**WEST SUSSEX COUNTY COUNCIL
STRATEGIC PLANNING CONSULTATION**

SUBJECT: EP/143/13 - New driveway and drop kerb to eastern boundary of property.

Middle Barn, The Street, East Preston, West Sussex, BN16 1JD

PROPOSED BLOCK & LAYOUT 1:500

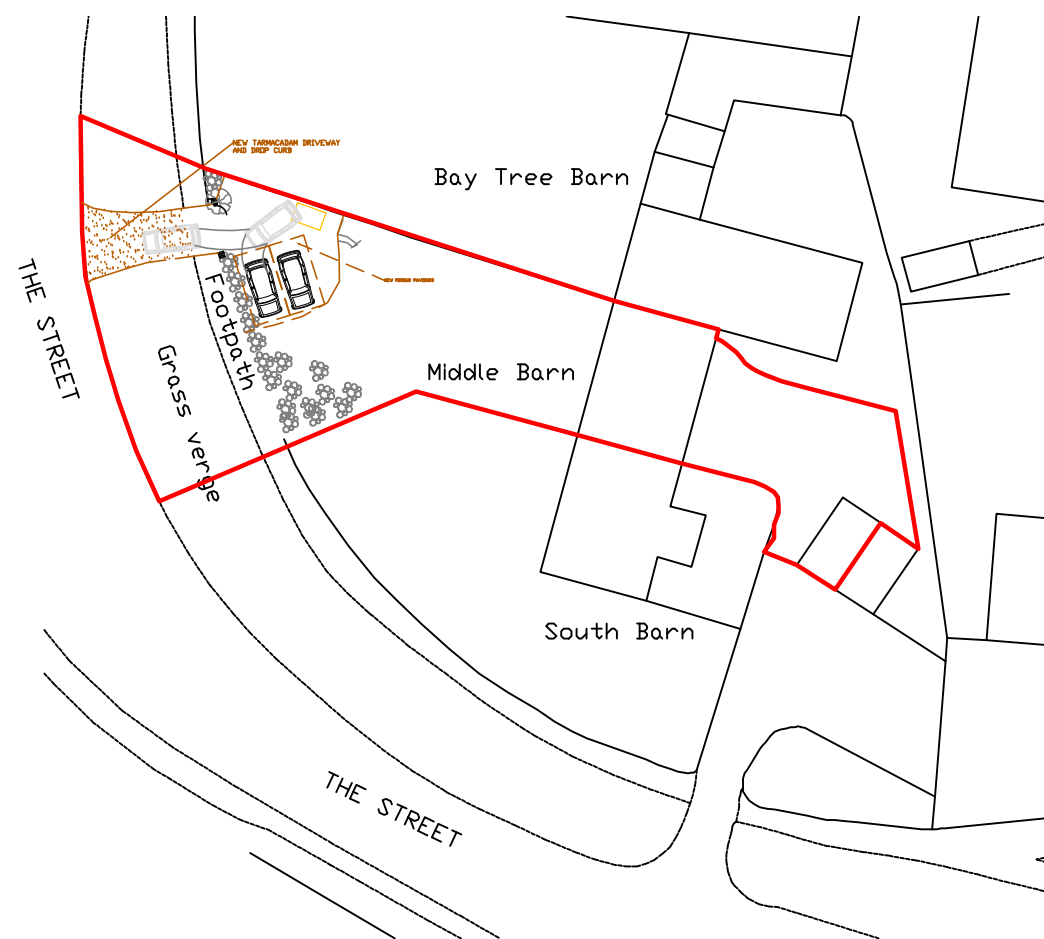
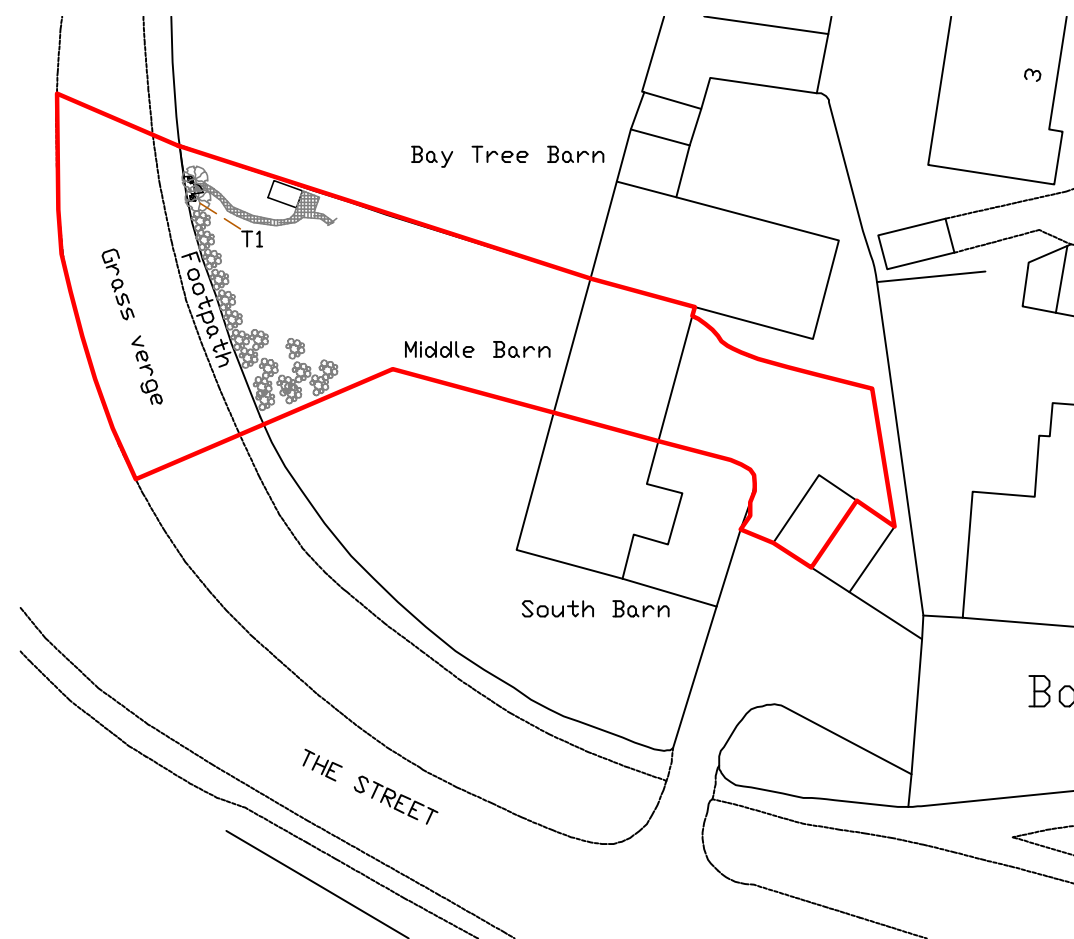
The application seeks approval for a new driveway and crossover on to The Street. In order to assess this application further WSSC will require further information on the following point.

No details have been submitted with regards to visibility splays at the new point of access. As The Street is a 30mph road, visibility splays of 2.4m x 43m (in line with Manual for Streets guidance) should be achievable with no obstructions over 0.6m and in land that is either within control of the applicant or within the highway boundary. As the proposed point of access is on a bend, it is important this information is supplied before we can formally approve.
